Application for a non-material amendment following a grant of planning permission.

Erection of 1 No. 2 bed dwelling	
Reference number:	FG/29/19/PL
Date of decision	06/06/2019

Alterations to internal layout, kitchen window amended and PV panels added on roof

1907 -2.01 revision A -Proposed Plans and Elevations

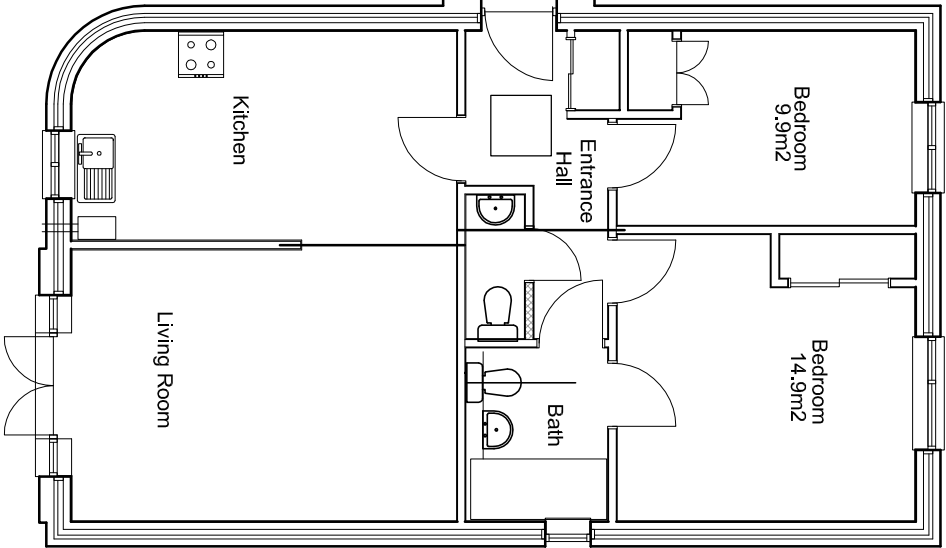
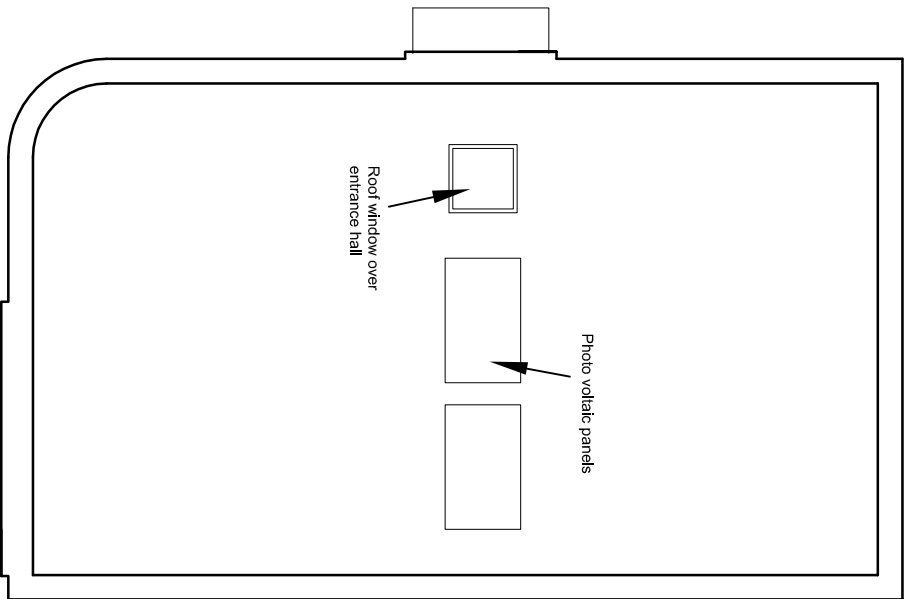
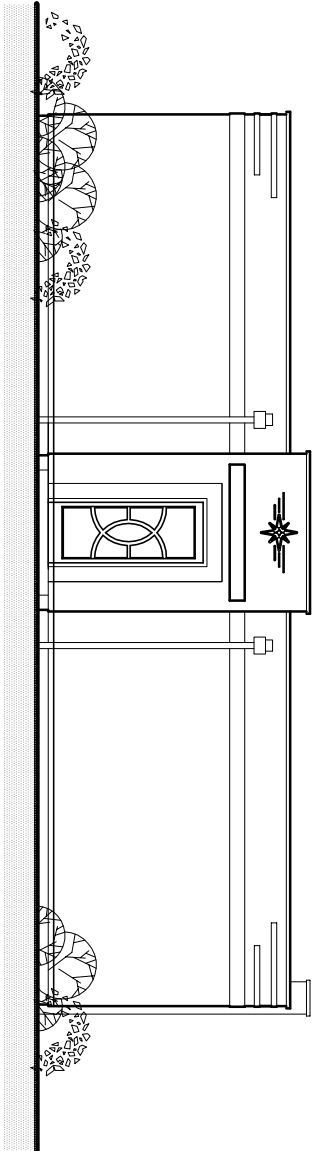
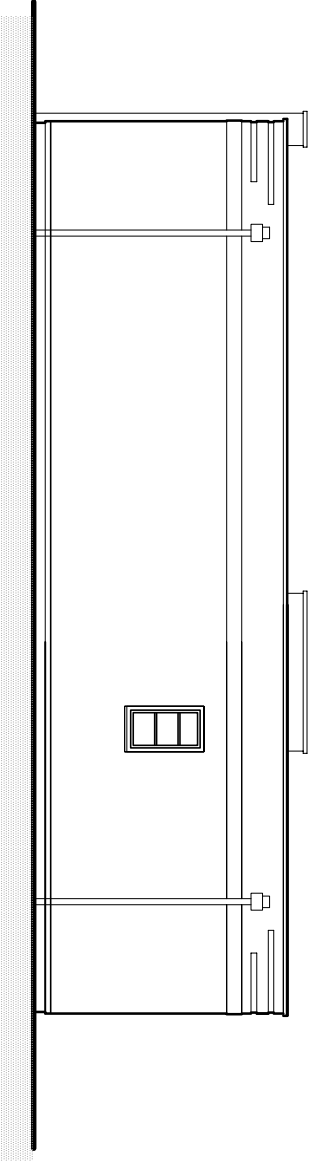
Improvements to internal layout and to improve energy efficiency
